Application by Awel y Môr Offshore Wind Farm Limited for an Order Granting Development Consent for the Awel y Môr Offshore Wind Farm project

The Examining Authority's written questions and requests for information (ExQ1) Issued on 27 September 2022

Esri UK, Esri, HERE, Garmin, INCREMENT P, USGS

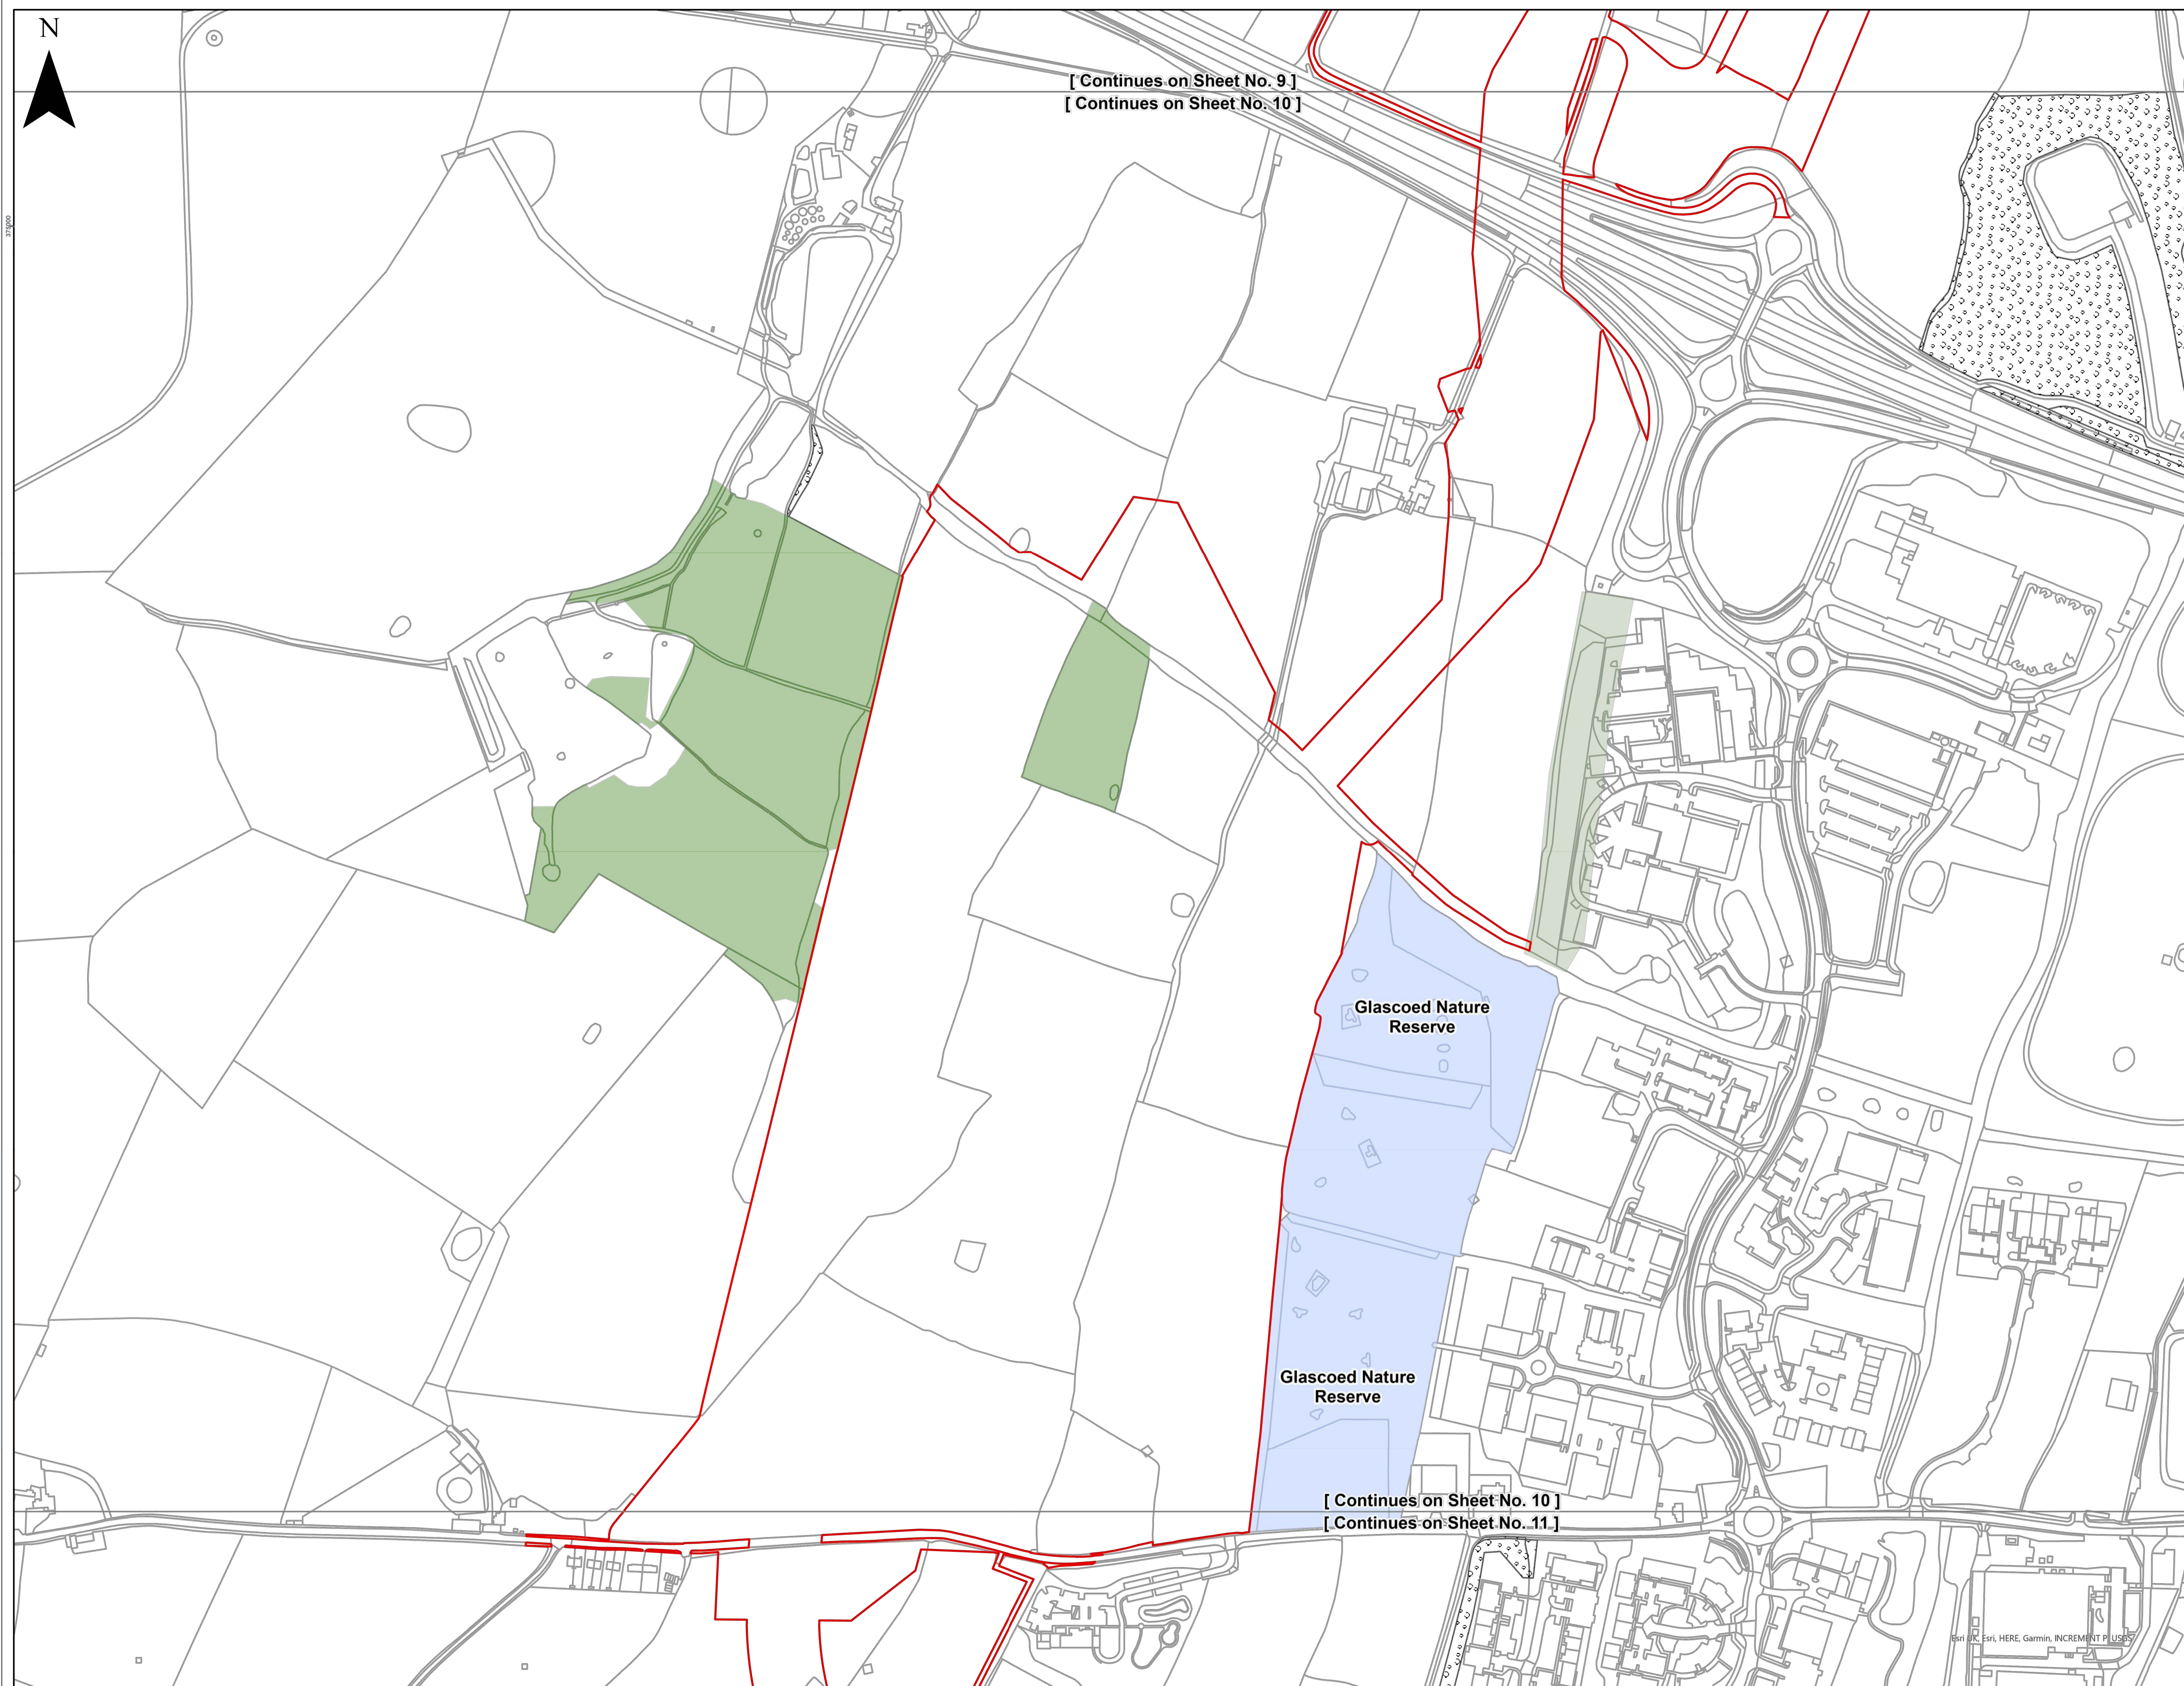
2.7	The Applicant	General Statutory / Non-statutory Nature Conservation Sites Plan [AS-010] Please can you address the following points: <ul style="list-style-type: none">a) Sheet 1 of 11 - The legend does not reflect all hatch colours shown and the extents of SPA hatch appears to be different on sheets 2 and 3;b) Sheet 2 of 11 –does the drawn shape and extent of Local Wildlife Sites at western edge reflects y Ffrith D011;c) differentiate the woodland area to help identify other ancient semi-natural woodland, plantation on ancient woodland site and local other woodland;d) label the name of the other nature reserves on the relevant sheet.
